18 October 2010
Ref 07246

Proposed Supermarket Development Wolli Creek

I have considered the findings of the Road Safety Audit undertaken by Geo Transport Solutions and the Corrective Action Requests.

DRAWING TITLE  
GROUND FLOOR  
PLAN - STAGE 1 & 2

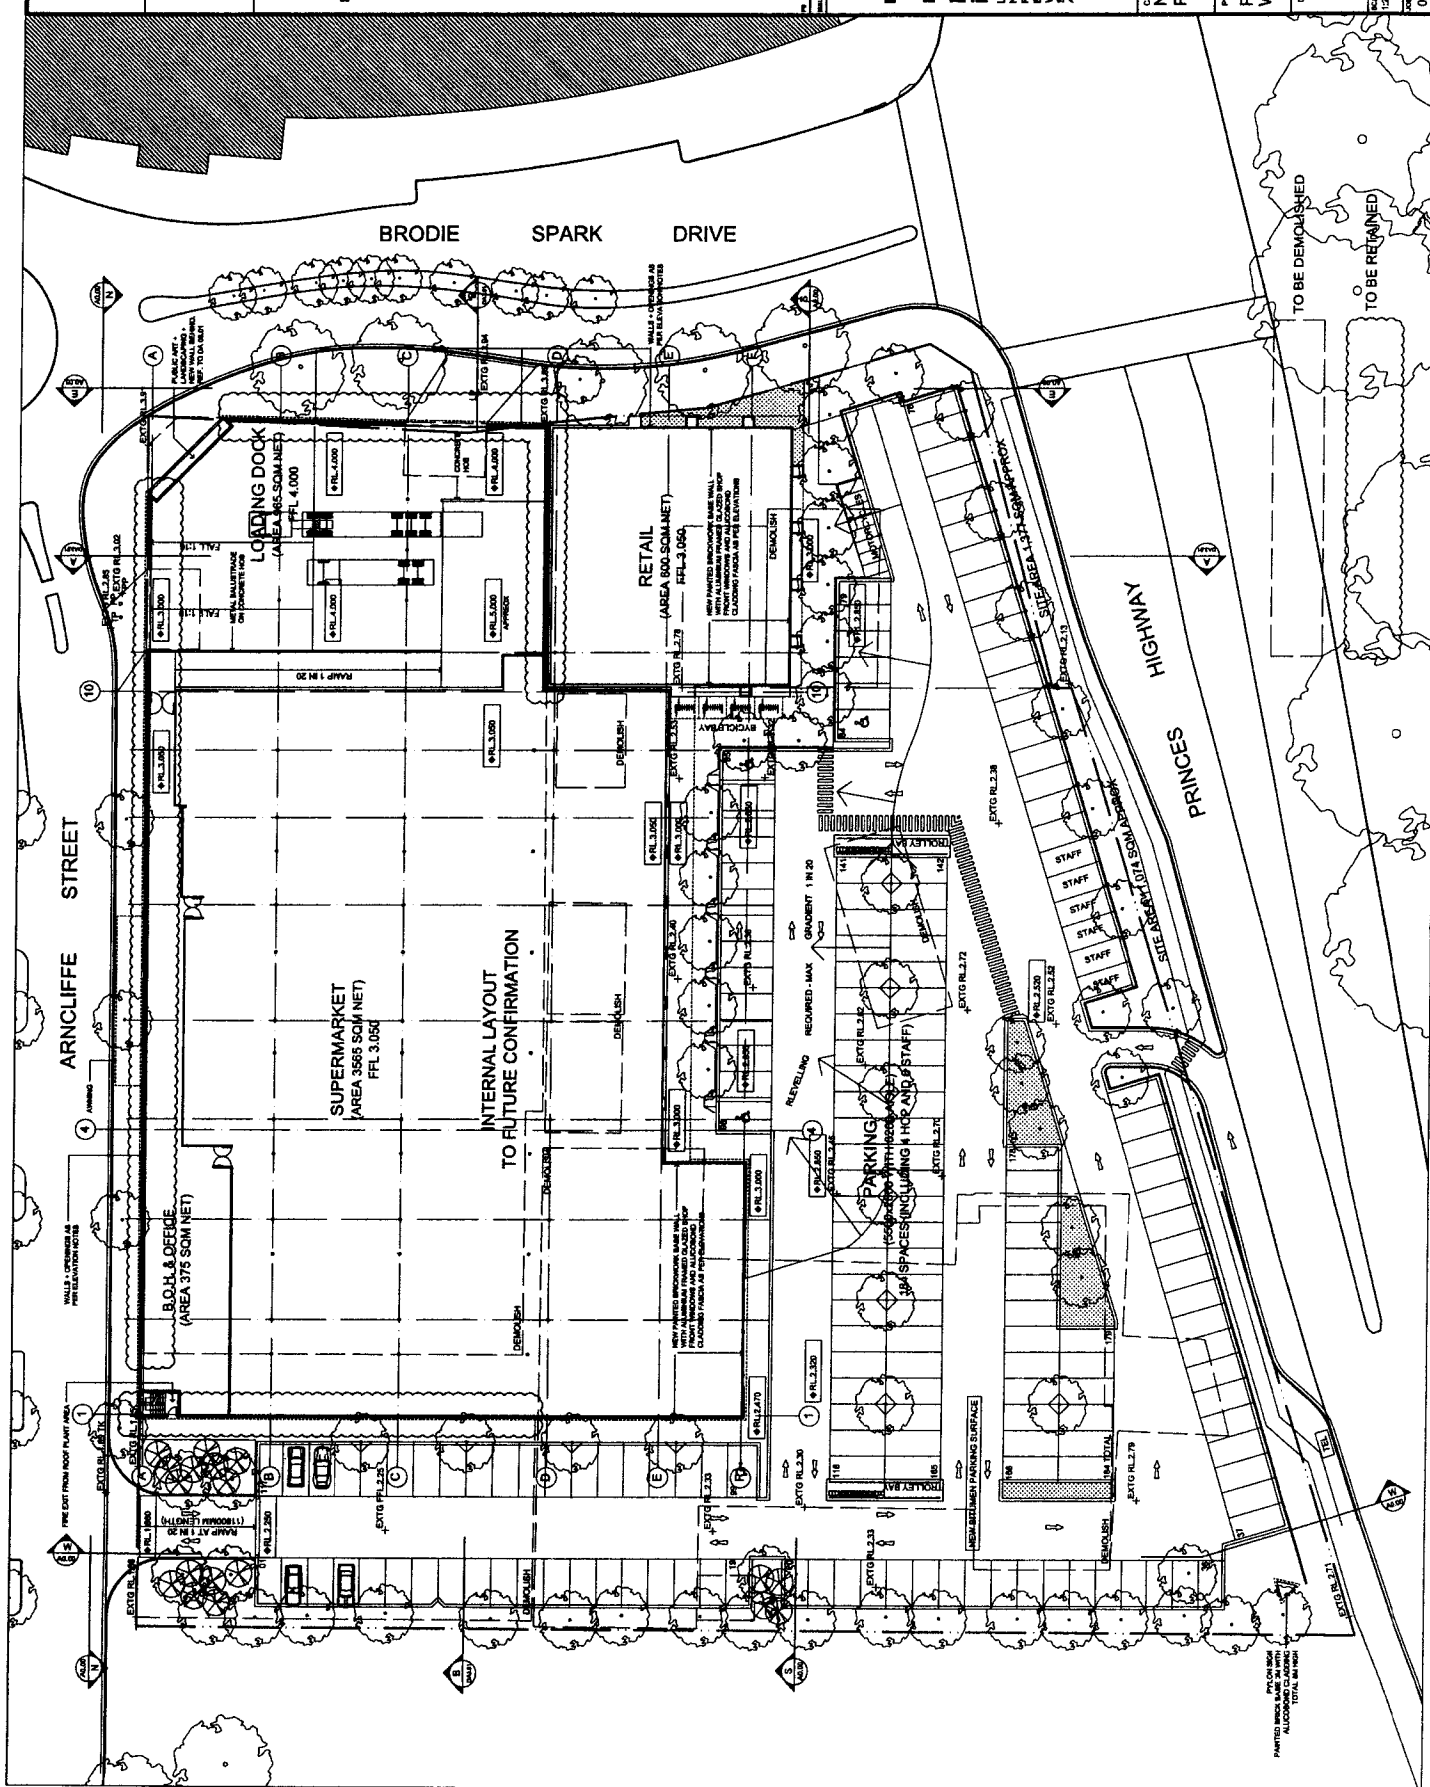
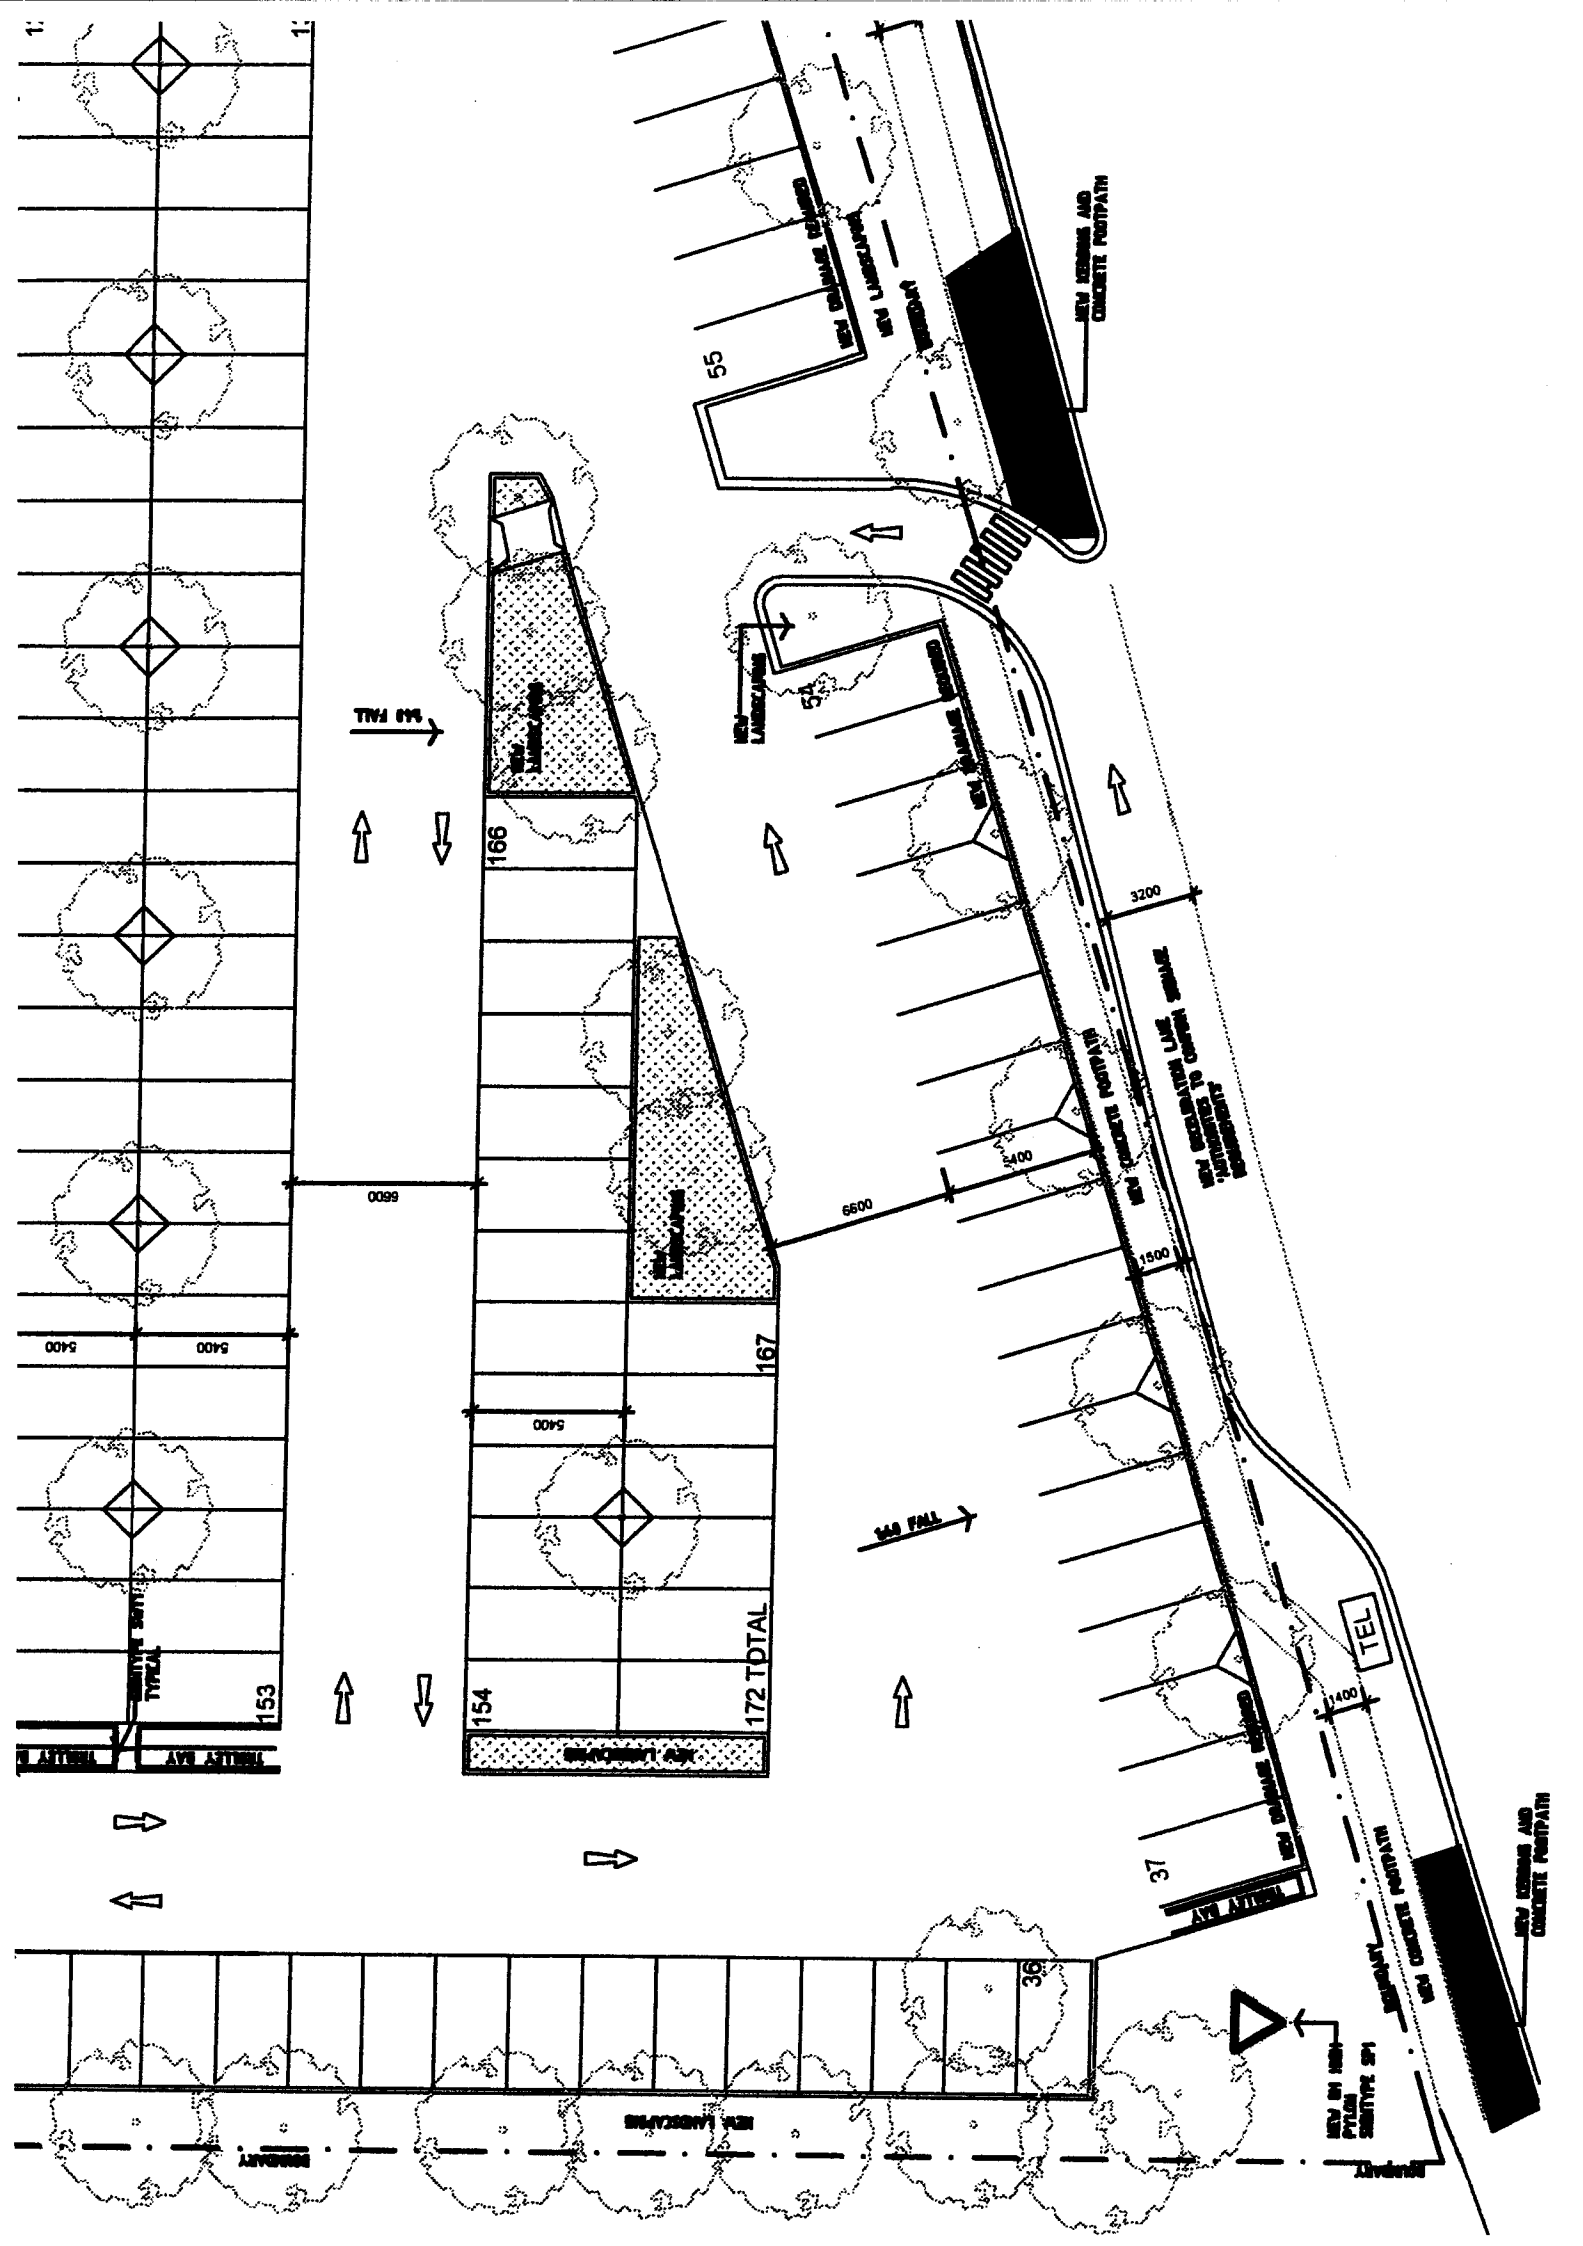
- * a 3.5 metres wide footway needs to be retained along the length of the left-turn lane
- * there is a need for linemarking and left-turn arrows along the lane
- * the pedestrian crossing should be deleted but kerb ramps added across the lane
- * GIVE WAY, ONE WAY and NO ENTRY signs should be added along with a GIVE WAY line at the point of entry.

A sketch incorporating the proposed modified access arrangement incorporating the corrective actions is attached for your to formalise and return for 'closing off' of the Corrective Action Requirements.
